Our Case Number: ABP-310286-21

Re: Railway works and all works necessary to eliminate and, where necessary, upgrade seven numbered level crossings and carry out all associated and ancillary works along a 24-kilometre section of the Dublin to Cork Railway Line.
Fantstown, Thomastown, Ballyhay, Newtown, Ballycoskery (Ballyhea Village), Shinanagh and Buttevant, Co. Cork and Co. Limerick.

Railway Order Application ABP Case Ref NA04.310286

Observations on behalf of the Trustees of the Diocese of Cloyne in regard to the proposal by Coras Iompair Éireann (CIE) to replace the manned level crossing at Ballycoskery XC212 with a new road and overbridge.

Figure 2.11: XC212 Ballycoskery Proposed Alignment

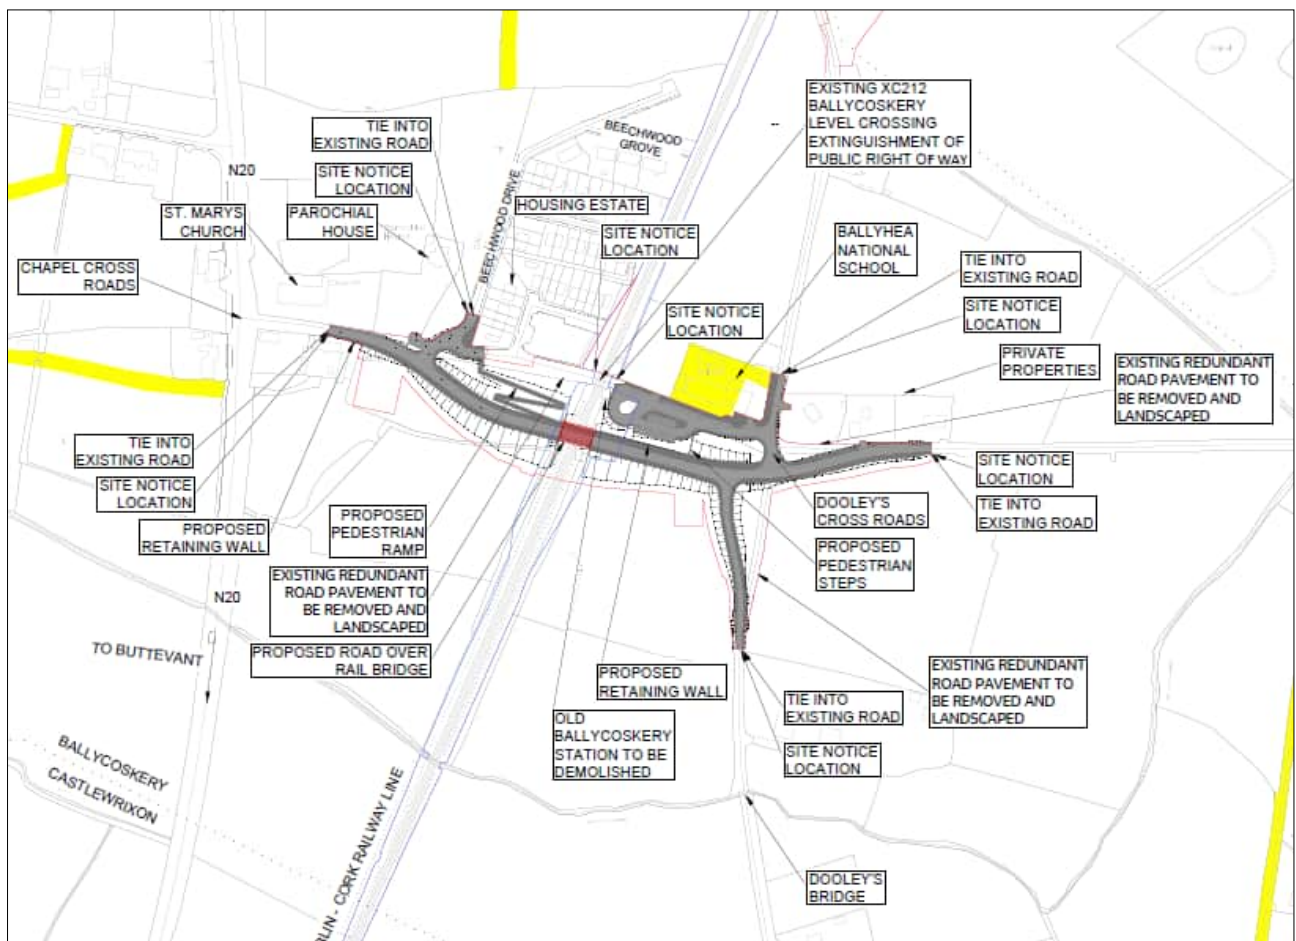
The scheme as shown in the LAP extends to a point midway between the entrances to Beechwood and the Parochial House whereas the proposed Project affects the entire frontage of the Parochial house and the western part of the frontage to the Church. This alteration to the physical extent of the scheme is likely to result in a major increase in the impact on the built heritage of the Church properties and particularly the setting of the gates to the Parochial House

The revised road and parking layout as proposed in the LAP is clearly a roads project to be implemented by the County Council as roads authority for the area. There is no reference to any justification for the scheme on grounds of rail safety and there is no indication as to whether the proposed road would cross the railway by an overbridge, underbridge or a four gate CCTV level crossing.
